Address: 48 Brown Hill Drive Bradford BD112AZ

Application number: 2025/90569	
What is the application for?:	Erection of single storey side and rear extension with associated alterations
Address of the site or building:	50, Brown Hill Drive, Birkenshaw, BD11 2AZ
Postcode:	BD11 2AZ

PROJECT			
50 Brownhill Drive Birkenshaw Bradford BD11 2AZ			
TITLE			
3D			
CLIENT			
Mr & Mrs Carroll			
DRAWN BY Author	CHECKED BY Checker	DATE 02/13/25	
SCALE (@ A1)		PROJECT NUMBER 0725	
DRAWING NUMBER A103			REV

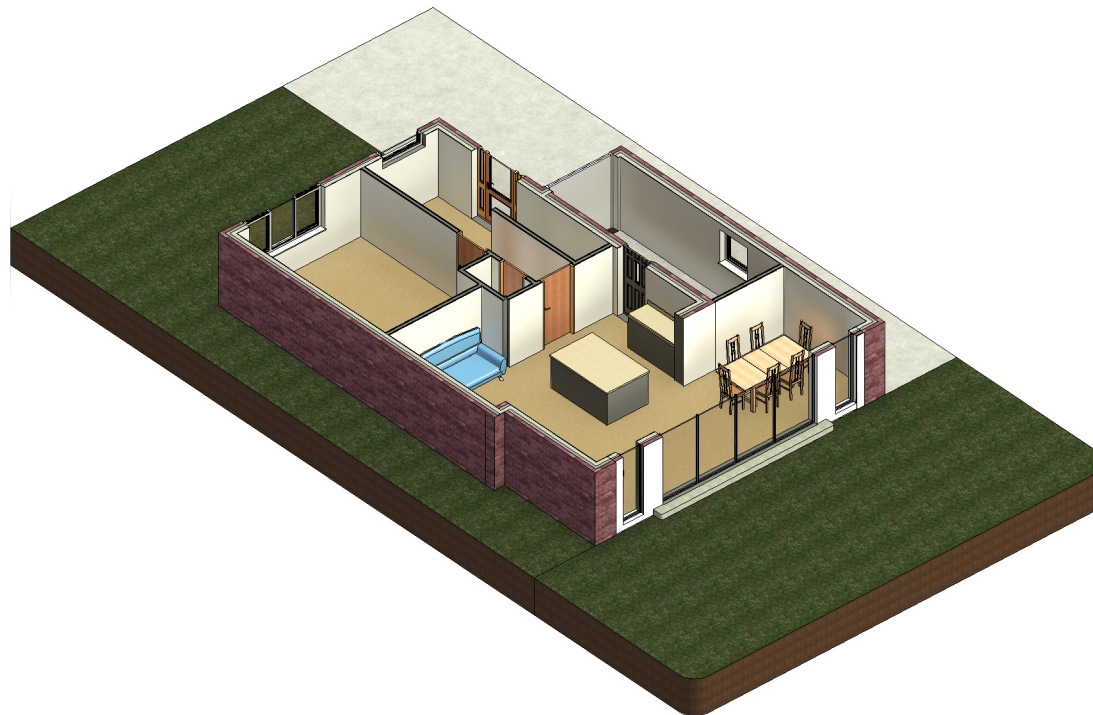
Type of comment: An objection	
Do you wish your comments to be published on the website anonymously?	No
Having looked further at the plans the fact that the proposed extension protrudes 3 metres from the existing rear wall and is close to the boundary of my house it would appear that given the height of the structure the existing light to my conservatory will be severely impaired. One of the main benefits of having the conservatory is to enjoy the summer evening sun. It would appear that this benefit will disappear if this development goes ahead at this scale.
